SUBJECT: Engineering Review Comment
Mountain View Electric Association Inc. (MVEA)

Project Name: Willow Springs Estates Filing No. 2

Project Number: VR264

Description: Proposed development of 2 residential lots located at 18050 Quarterhorse Ln. in Township 11S, Range 65W, Section 15.

Willow Springs Estates Filing No. 2

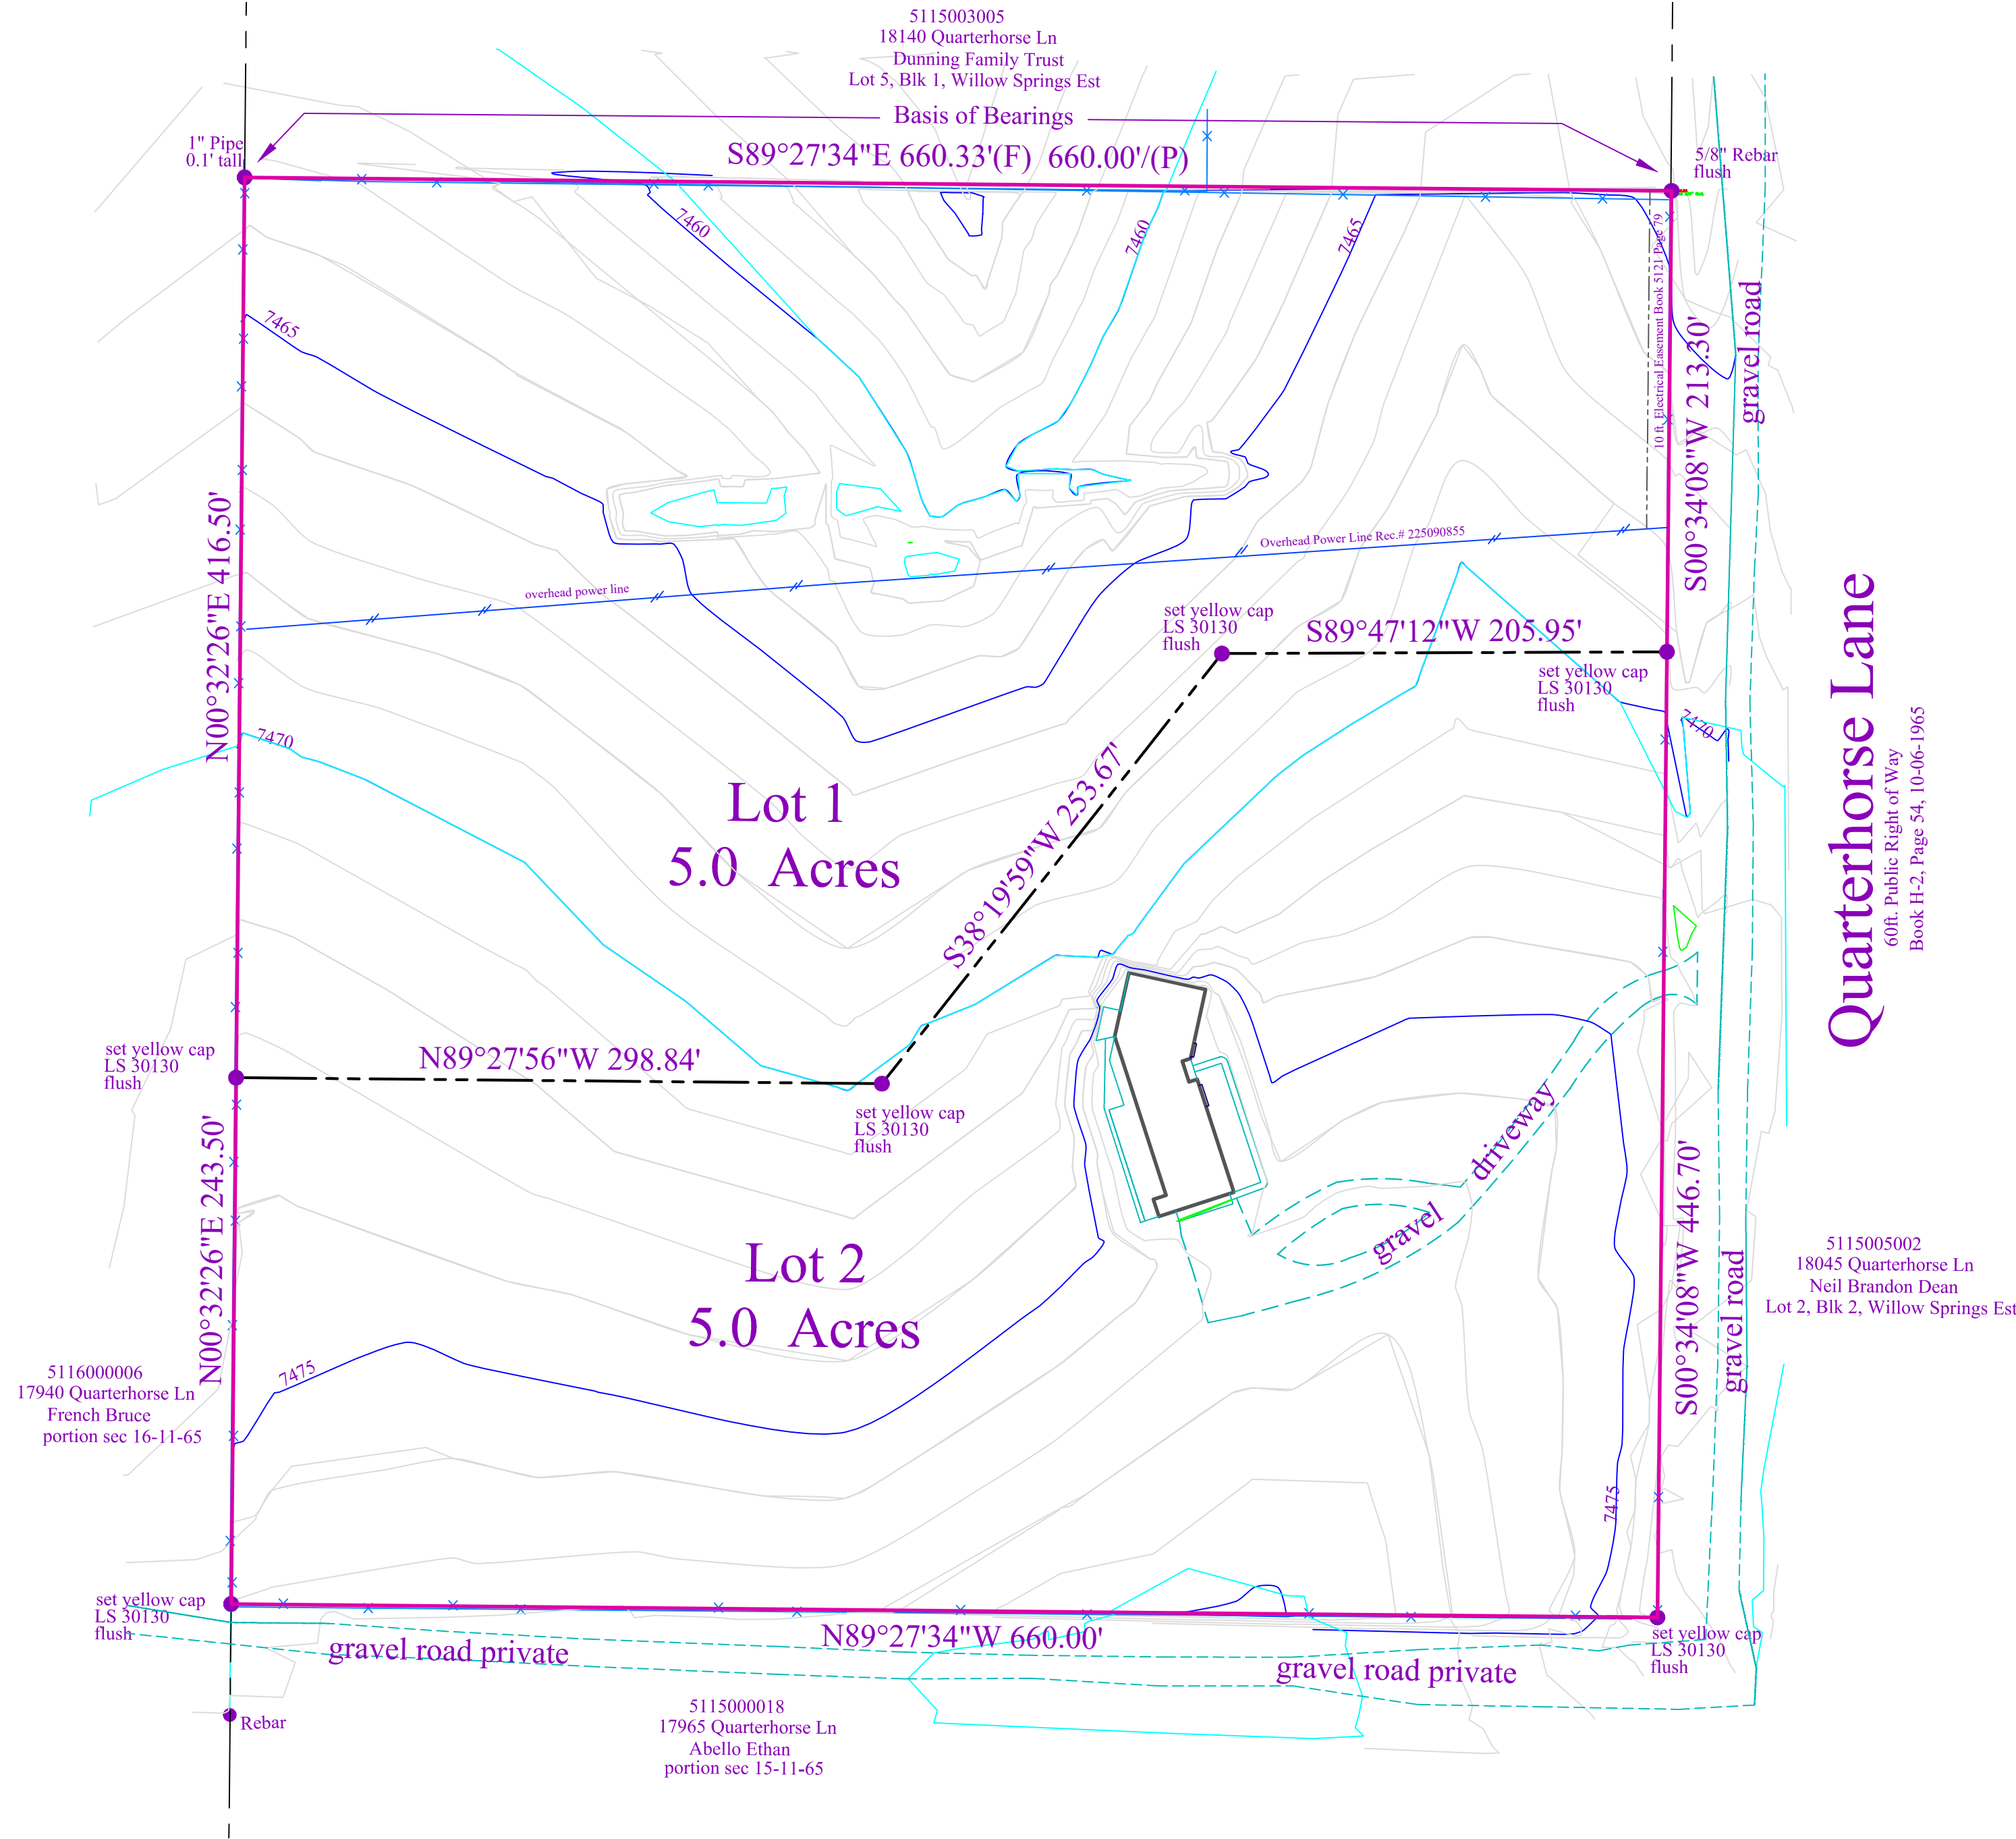
MVEA requests a ten (10) foot front, side, and rear lot utility easement and all tracts, along with a twenty (20) foot exterior utility easement on the plat. MVEA also requests the platting of MVEA's existing facilities with easements on the plat. Additional easements may be required.
